COMBINED PRELIMINARY AND FINAL
DRAINAGE REPORT
for
OHANA SUBDIVISION
EL PASO COUNTY, COLORADO

El Paso County Certification: Filed in accordance with the requirements of the Drainage Criteria Manual, Volumes 1 and 2, El Paso County Engineering Criteria Manual & Land Development Code as amended.

FINAL PLAT OHANA ACRES

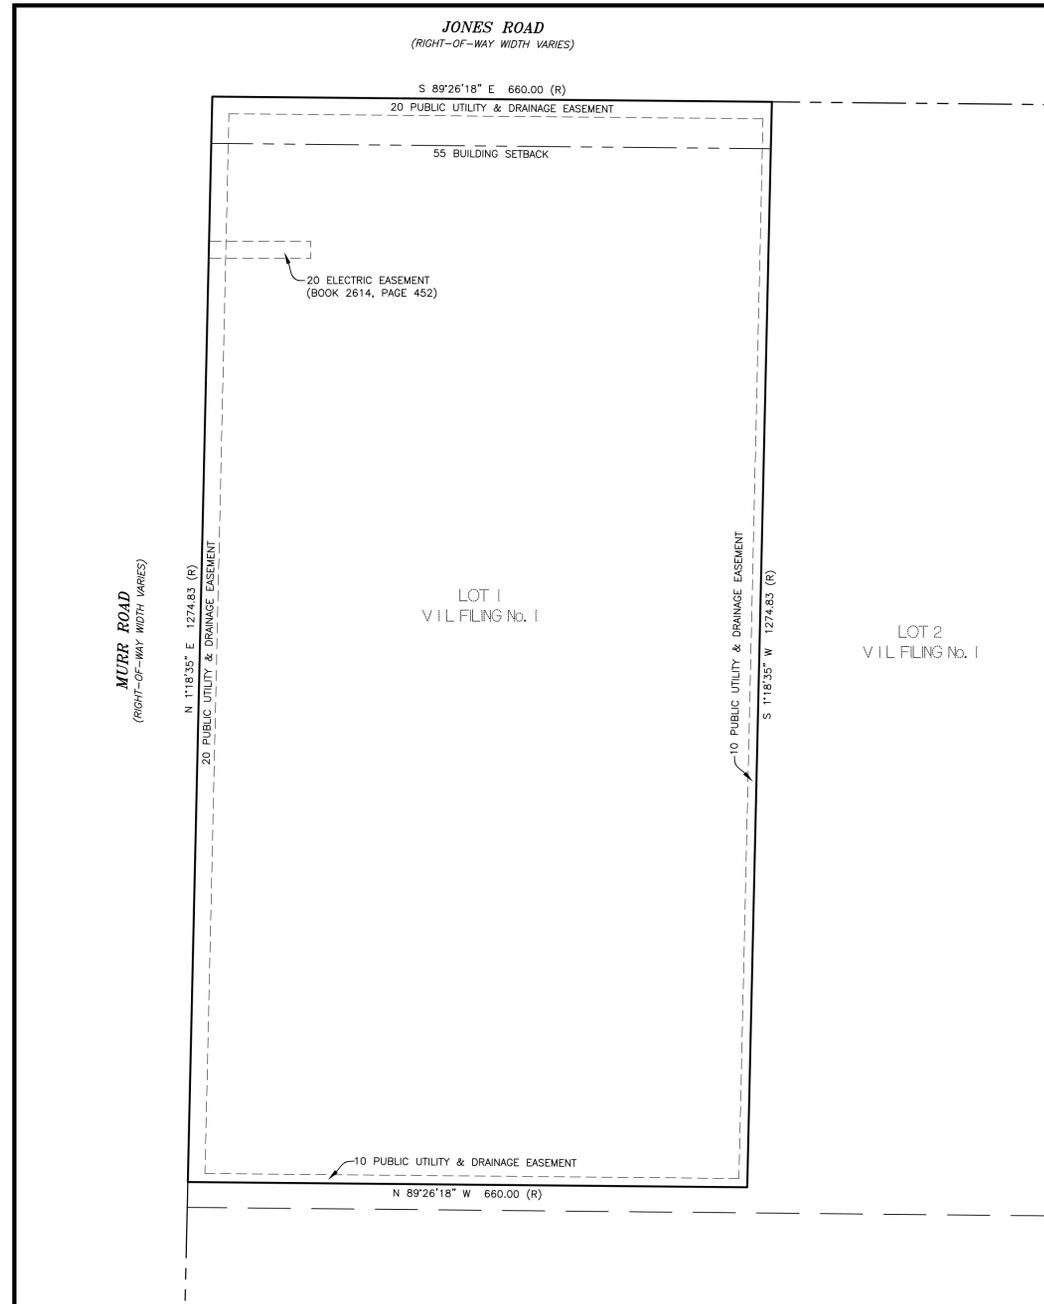
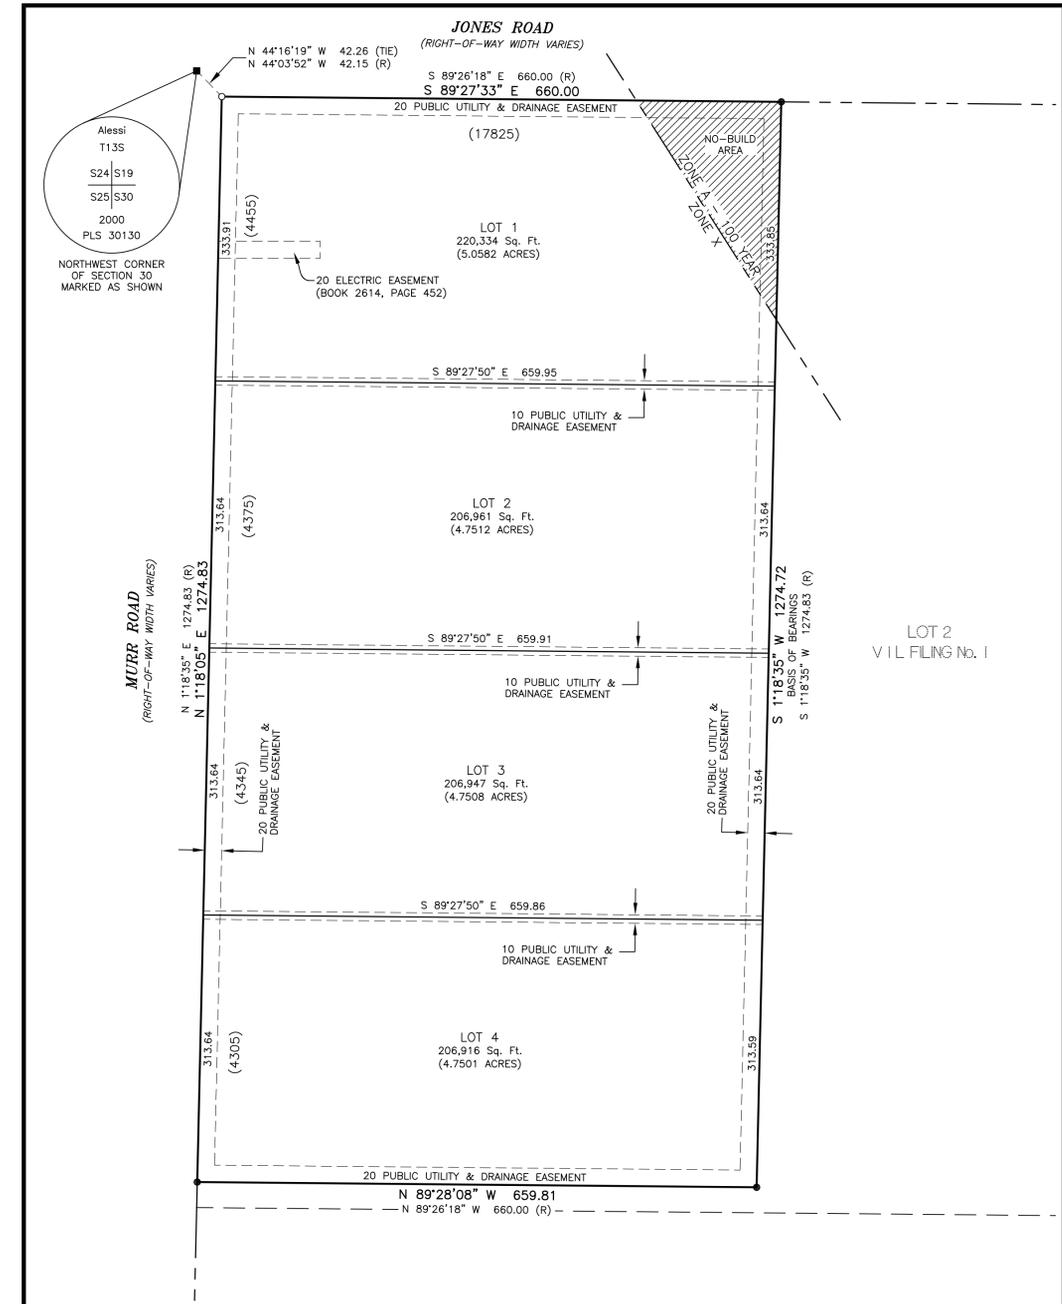
Need to clearly show what is existing vs. what is proposed.

Rotate map so text is upright and north points to top of page.

Provide map that is to scale & provide legend

Label all adjacent property owners

Show drainage arrows

Show and label existing culvert mentioned in report

Missing easement lines for this note.

It appears that there is a ridge running through the project site. A drainage basin with flows for each will need to be shown and calculated.

Fix overlapping text

Label no-build area for floodplain

Not sure of the intent of this statement as there are higher elevations along the roadway.

Per EPC GIS information an existing culvert crosses Jones Rd at intersection. Please show and label.
